Subject: Exhibition - Upper South Creek Advanced Water Recycling Centre (SSI-8609189)

Attachment 1 – EES on the Upper South Creek Advanced Water Recycling Centre (SSI-8609189) EIS and technical reports

**Figure 4-10 WorleyParsons (2015) and AWRC study 1% AEP flood extents using ARR 1987 Guidelines**

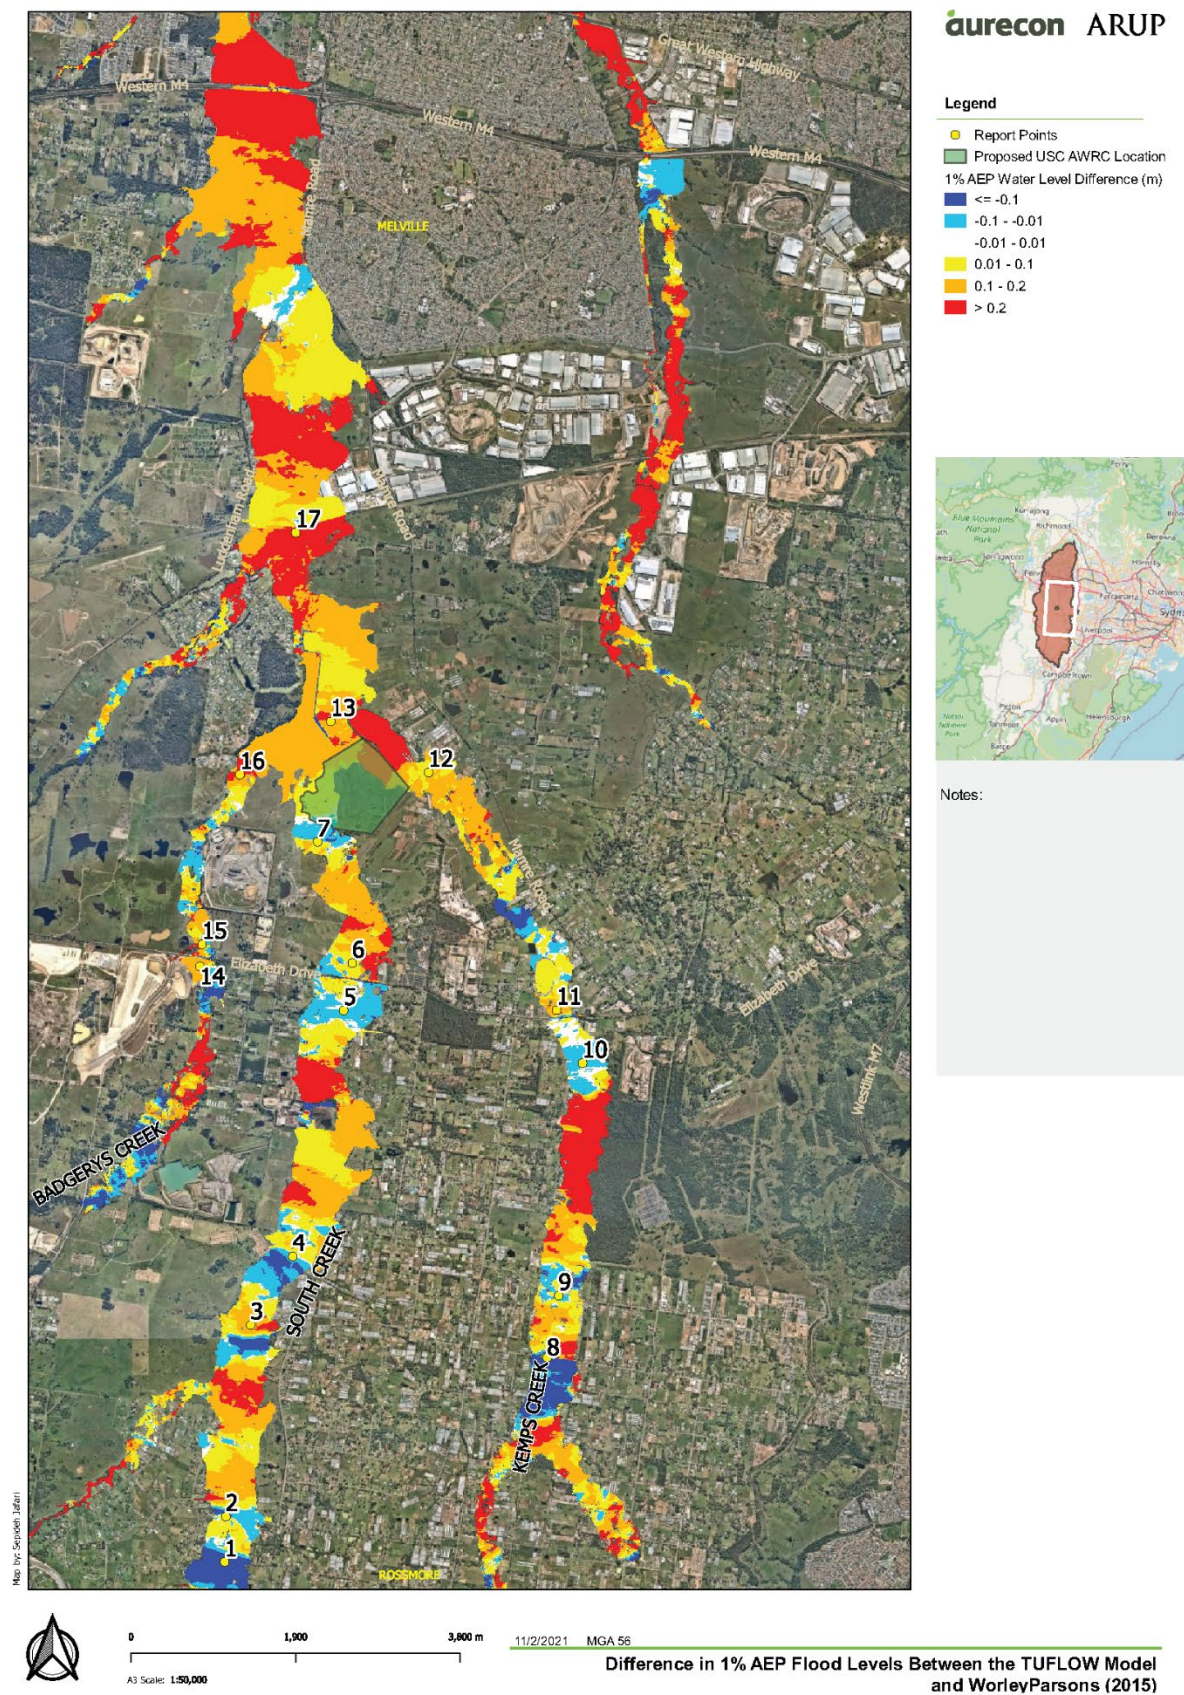
The consultants benchmarked a TUFLOW hydraulic model that applied inflow inputs from the XP-RAFTS 1987 hydrologic model and presented the results in Table 4-7, Figure 4-10, Figure 4-11 and Figure 4-12. However, the actual USC AWRC TUFLOW hydraulic model that was utilised for the existing case of Aurecon ARUP 2021 Flood Impact Assessment applied inflow inputs the AWRC XP RAFTS model ARR2019.

Flood consultants understand that, changing the inflow inputs into a hydraulic model will result in different model results. Therefore, the consultant’s discussion on validation of both hydrologic and hydraulic models as presented in Section 4.3 and Section 4.4.7 is misleading and incorrect. The modelling approach is neither sound nor appropriate to inform the modelling results of the flood assessment.

EES recommends the proponent amend the Flood Impact Assessment and adequately address the following requirements.

Identifying existing flood behaviour (pre-development condition) for the full range of floods up to and including the probable maximum flood. The FIRA should outline and map existing flood behaviour based on the *Wianamatta (South) Creek Catchment Flood Study - Existing Conditions* report (final, version H, 25 Nov 2020) which is consistent with Penrith City Council's adopted flood studies and flood risk management study and plan. INSW has previously provided this information to the proponent.

**Figure 6-4 Existing case 10% AEP peak flood levels and depths**

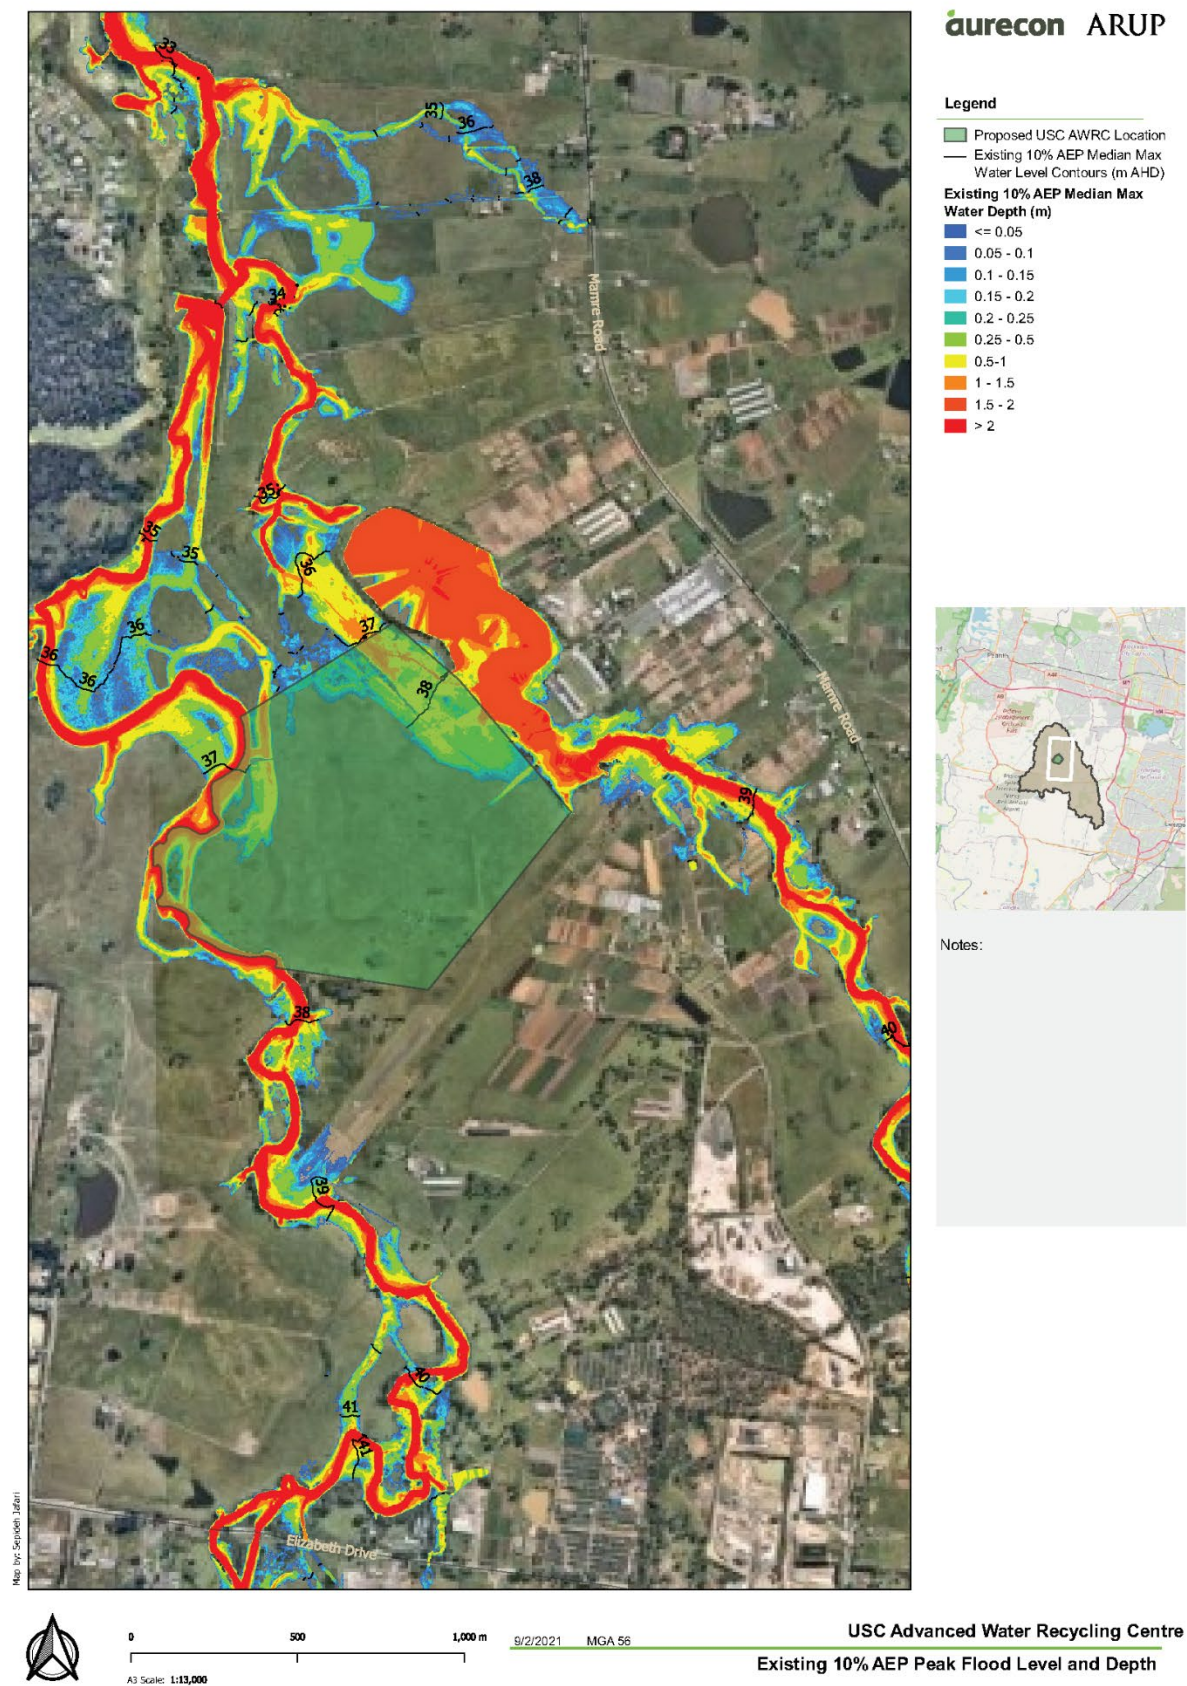
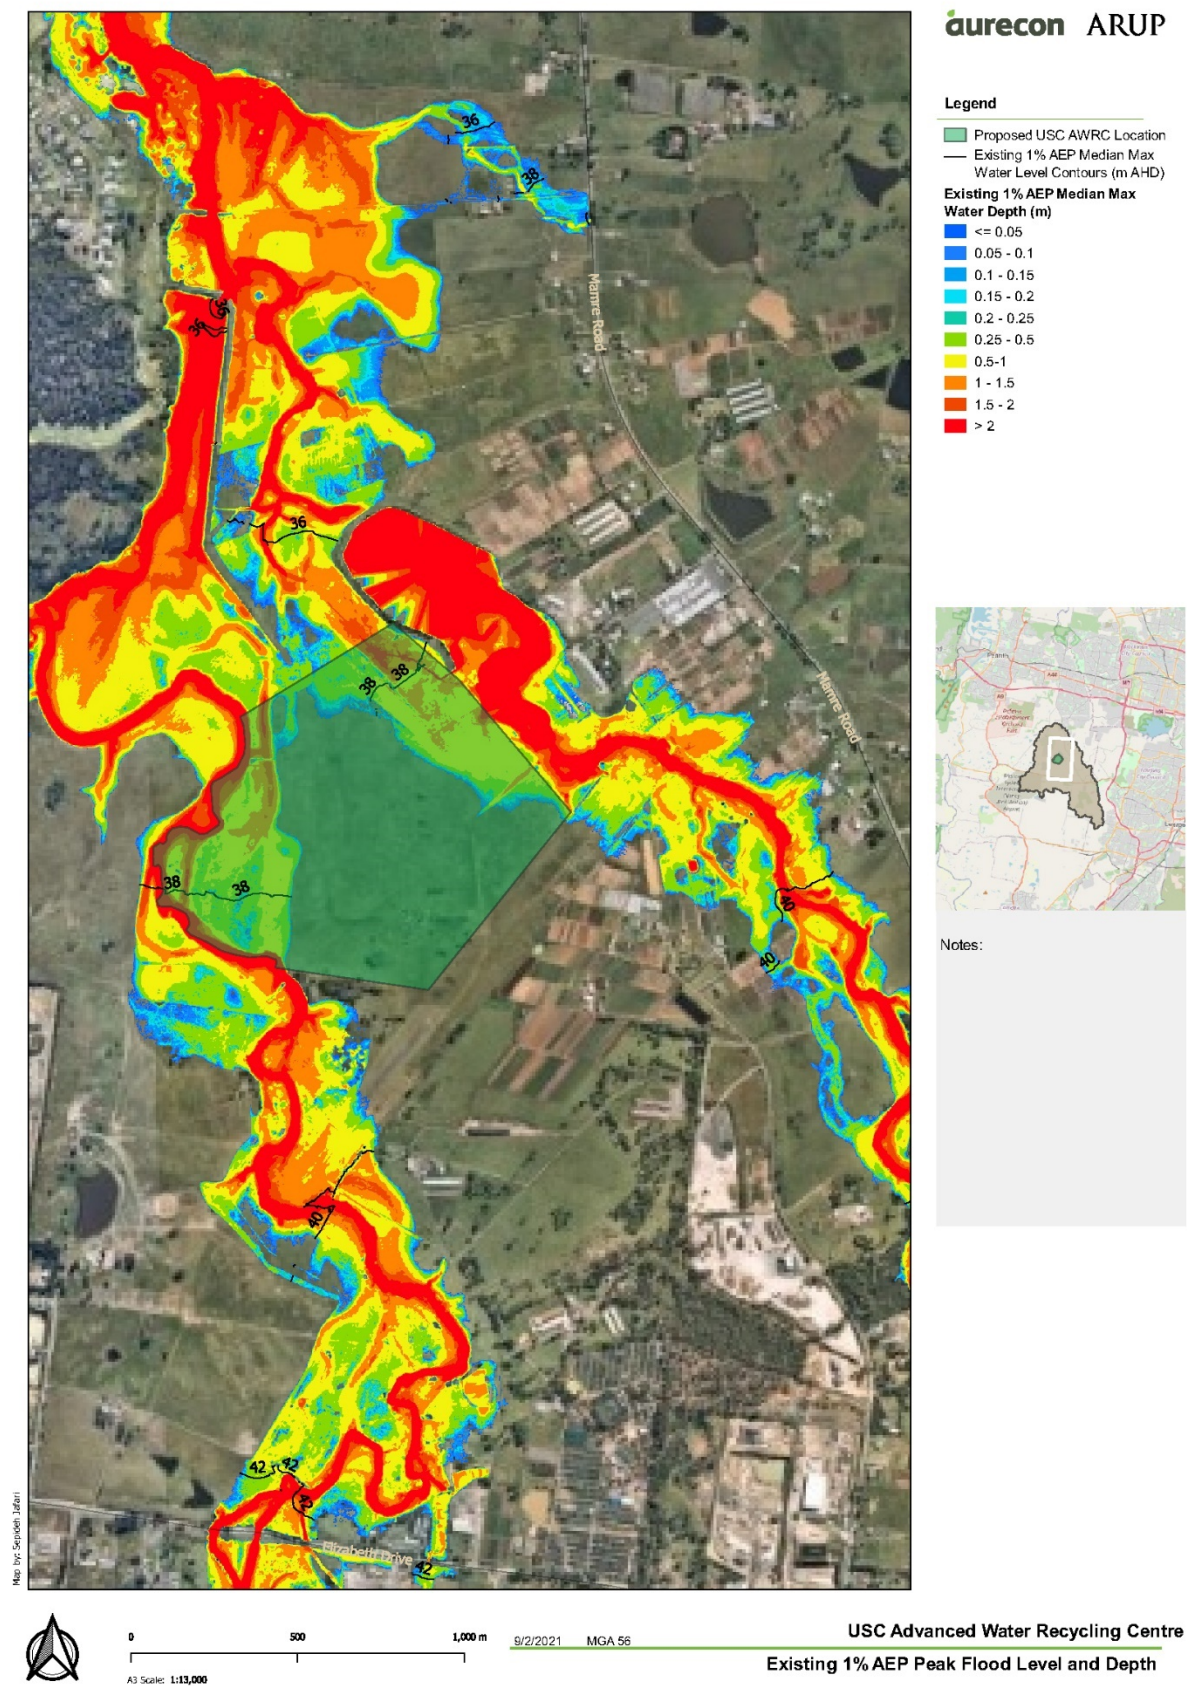
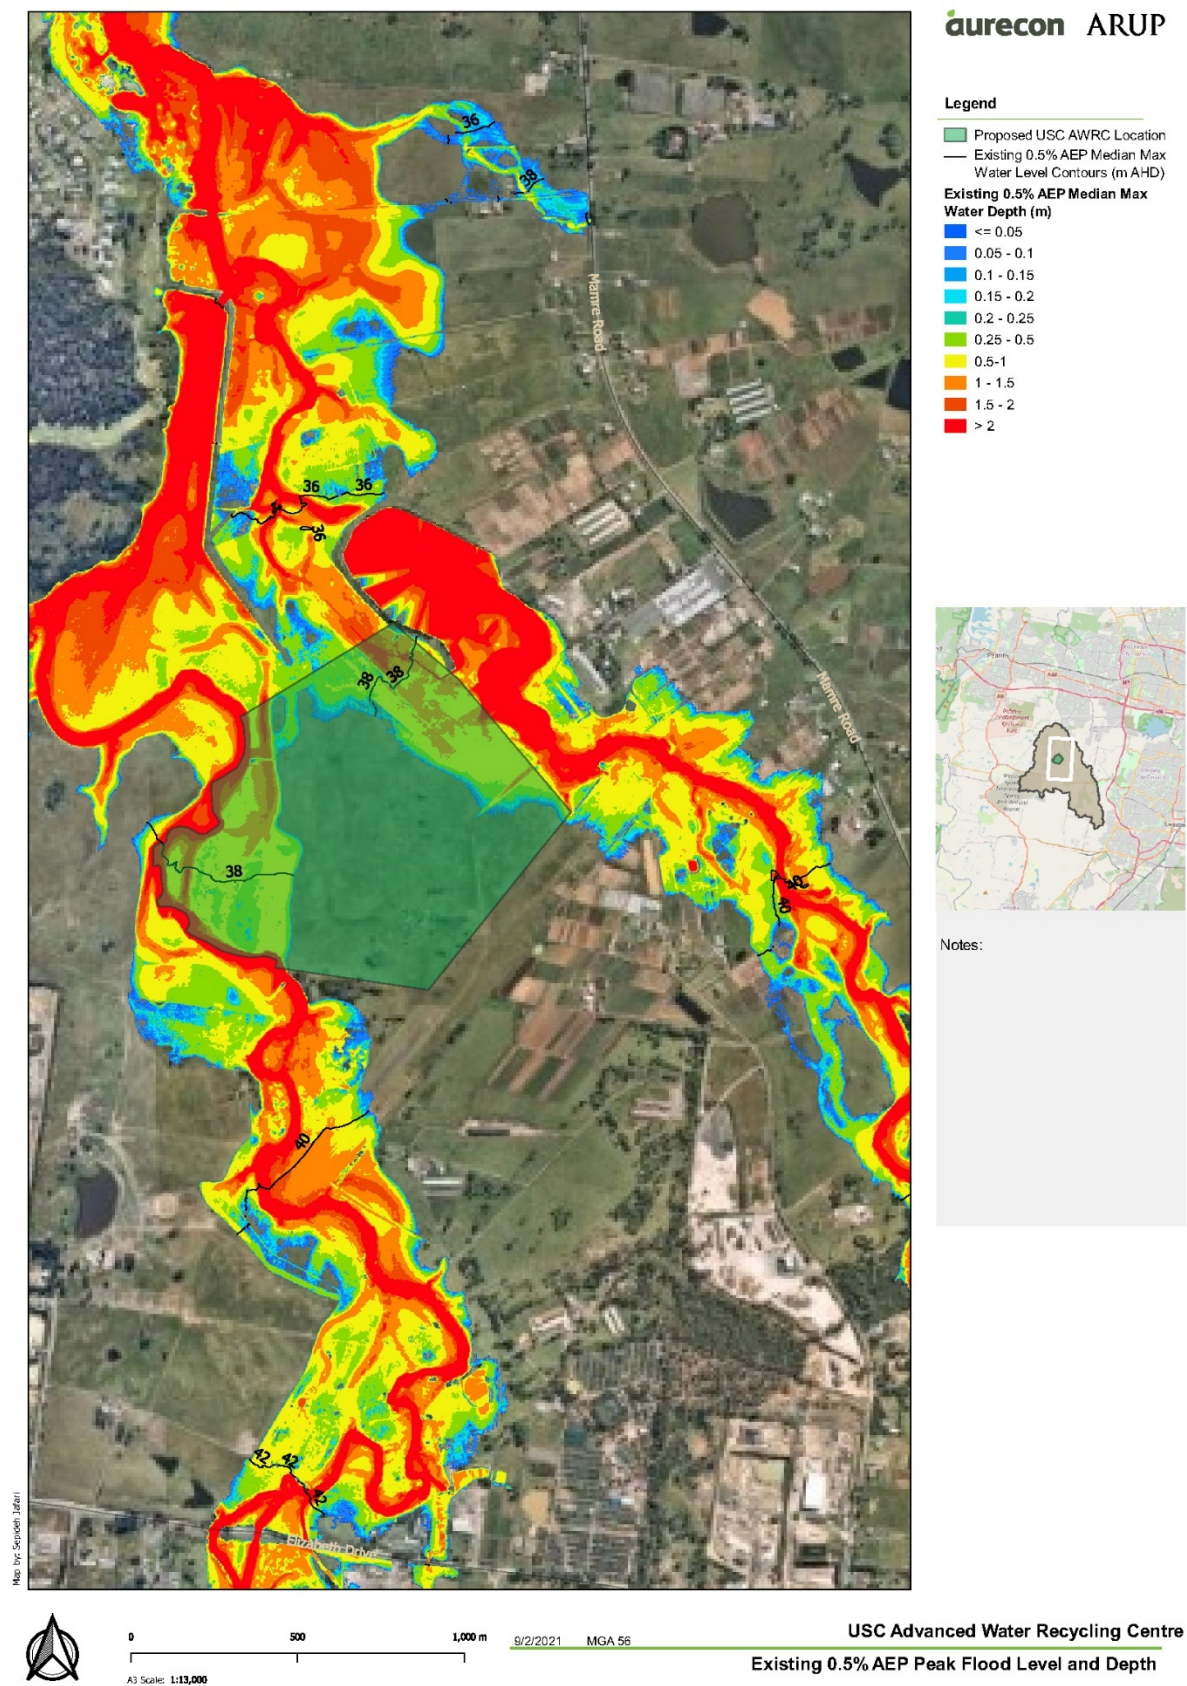
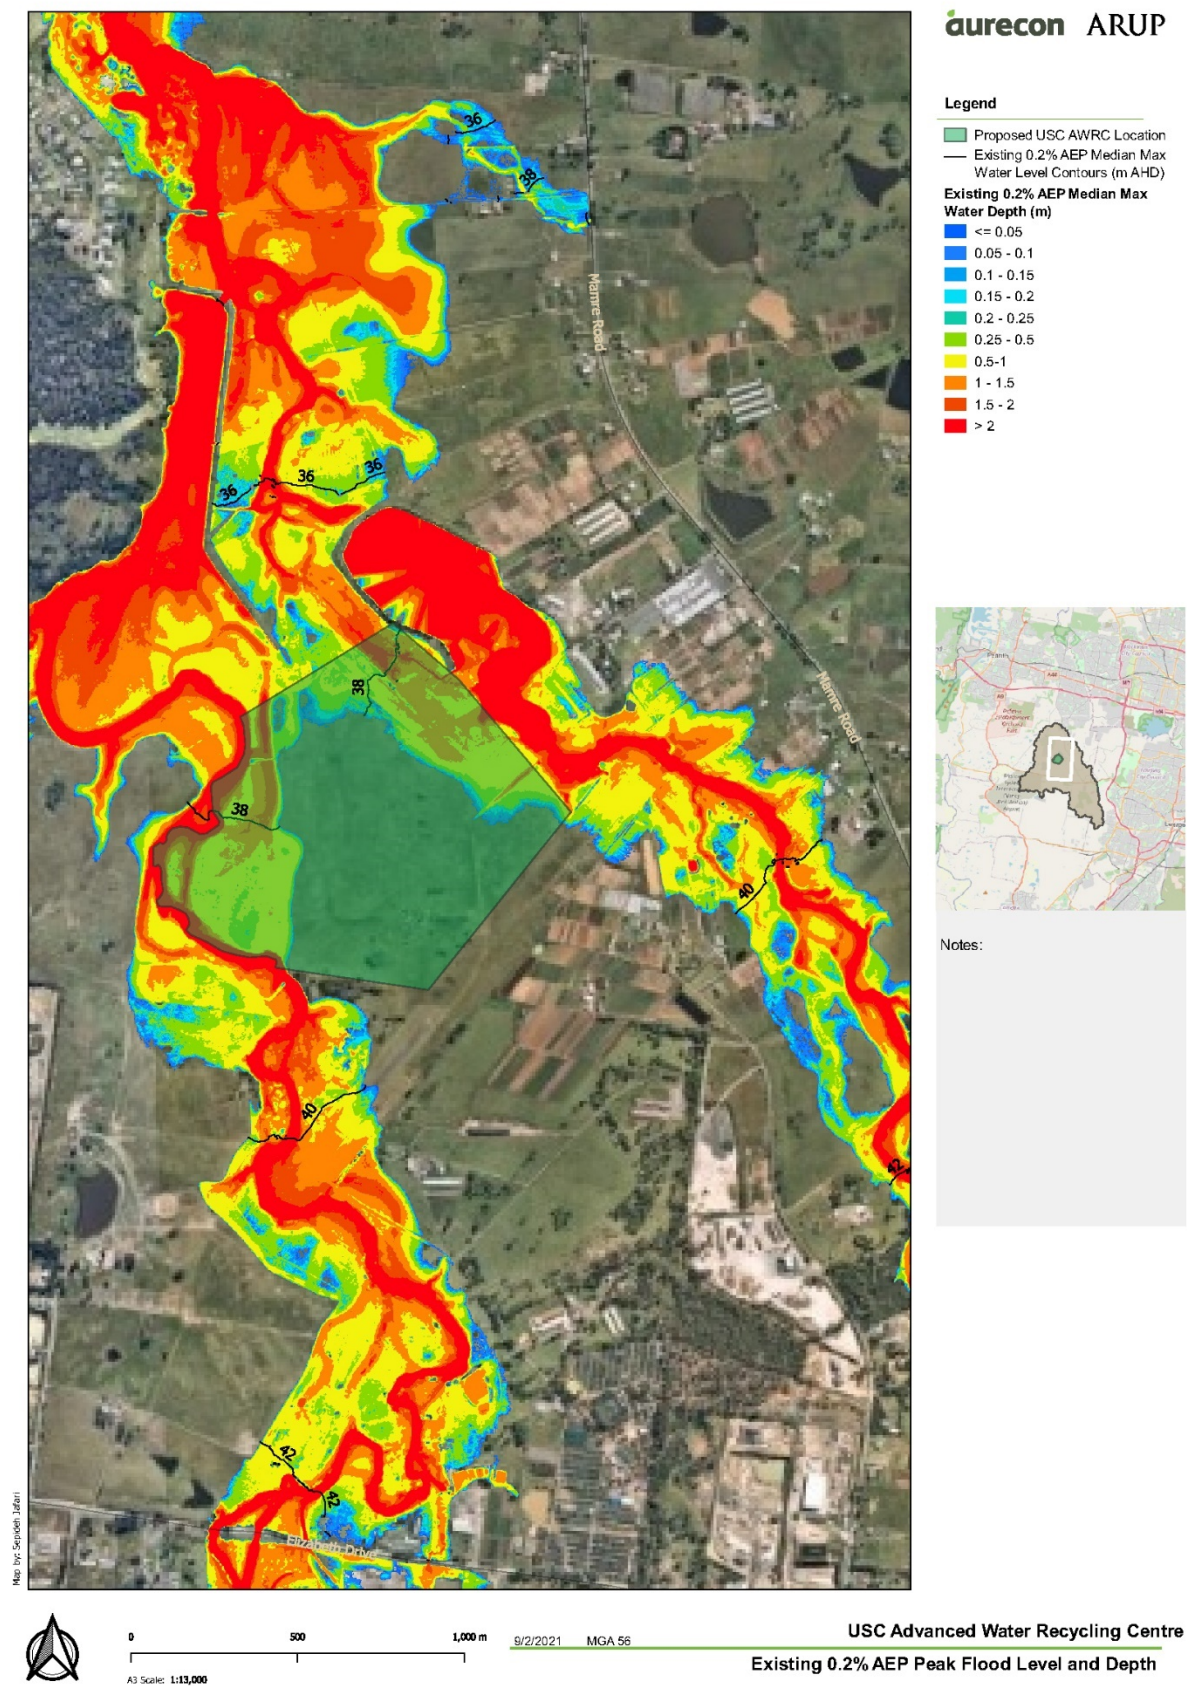
Accordingly, all results presented in Figures 6-4 to Figure 6-30 for the ‘Existing Case’ presented in Section 6.2 are not consistent with Penrith Council’s South Creek adopted Flood Study

(WorleyParsons, 2015). All reference in the titles of the figures presented in Section 6.2 that they are based on WorleyParsons (2015) are misleading and incorrect.
